Robert **Bird** Group

Civil & Structural Engineering Review
Report, of

**CBD and South East Light Rail (CSELR)
Project
Environmental Impact Statement (EIS)**

Document No.: 13895 – RBG – ATC - 001

Impact Plan 02
Wansey Rd Stop

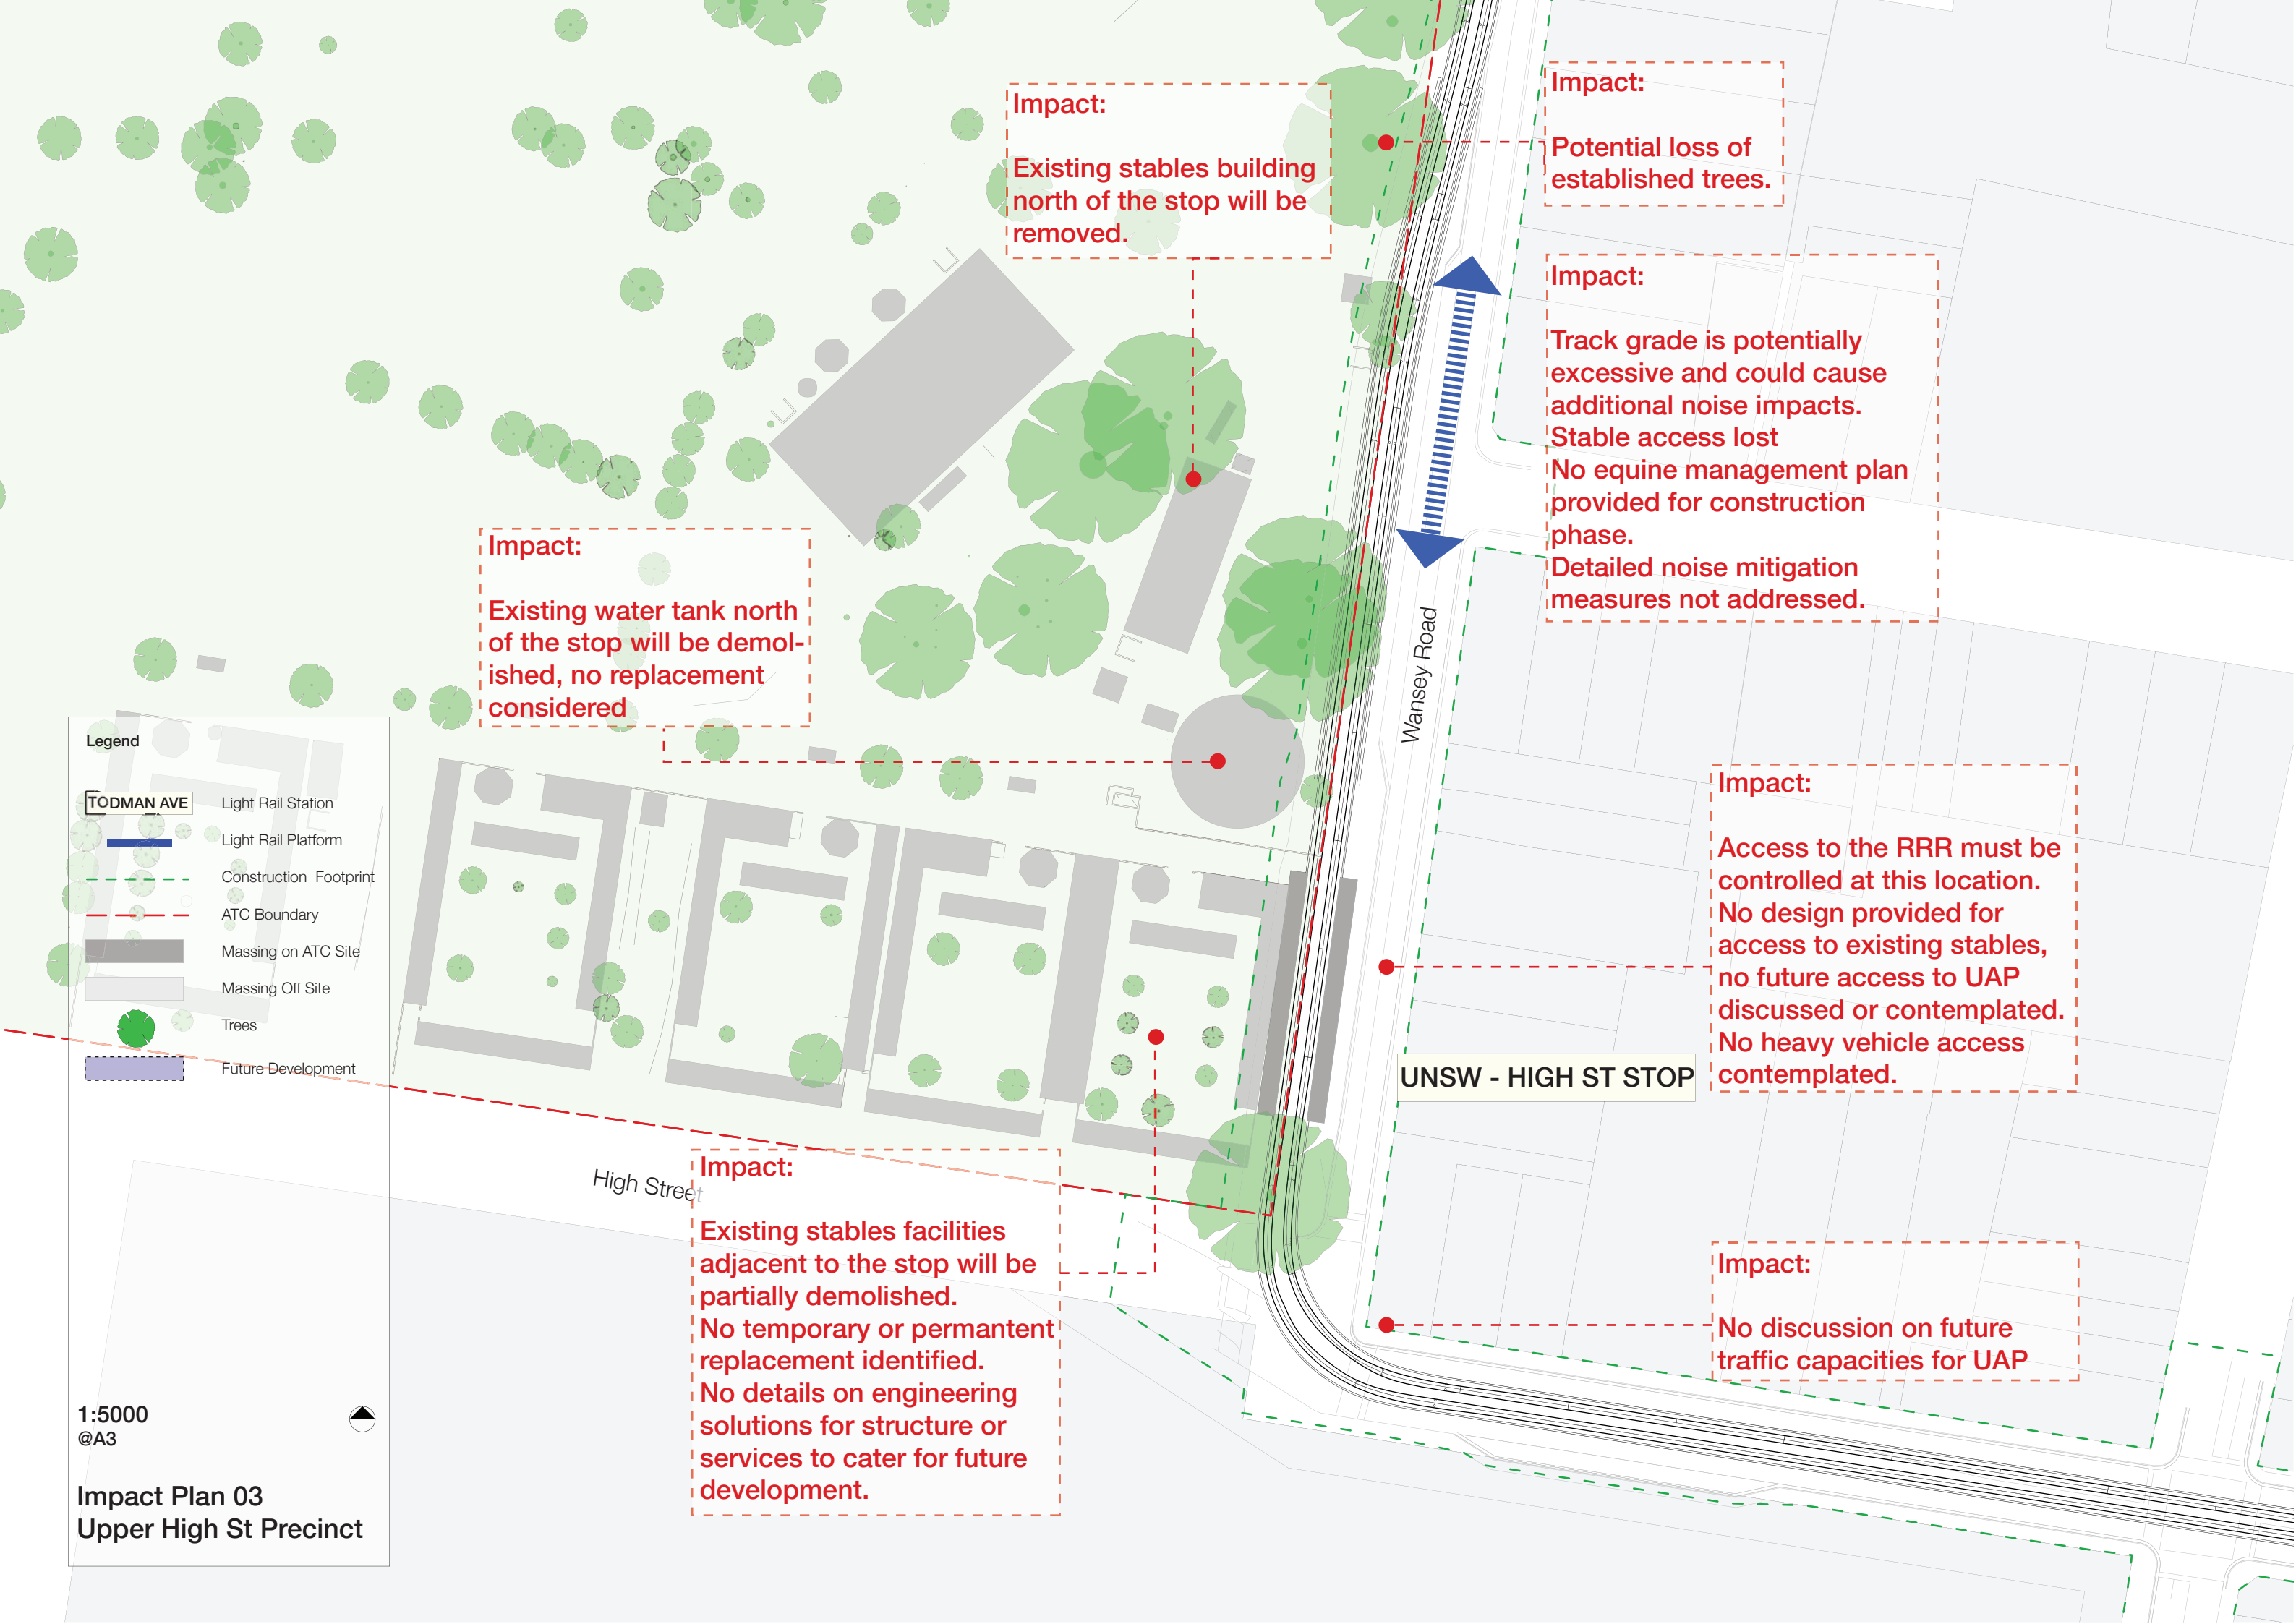
EIS Section 5.6.2 details a suspended shared path over ATC land. The path is suspended off a new concrete retaining wall founded on piles. Wansey Road existing retaining wall to be replaced. Approximately 125m in length up to 4.5m in height. The retaining wall requires land acquisition from ATC.

Construction of the retaining wall will likely impact RRR to enable construction of the piled footing (loss of trees and piling rig access), and maintenance of the suspended path will likely require an easement inside RRR for inspection and maintenance access. The easement must not impact current ATC operations and must cater for the proposed UAP development including basement structure to be constructed without interfering with the High Street and Wansey Road stops.

Treatment of the retaining wall to be confirmed, and considered in relation to the amenity of the future stables development.

A fence providing screening of Royal Randwick Racecourse (RRR) is required from the suspended path to horse training and stabling areas.

RRR vehicle clearances from suspended path to be considered. A vehicle exclusion zone is likely to be required to prevent impacts on the structure. This may impact RRR circulation.
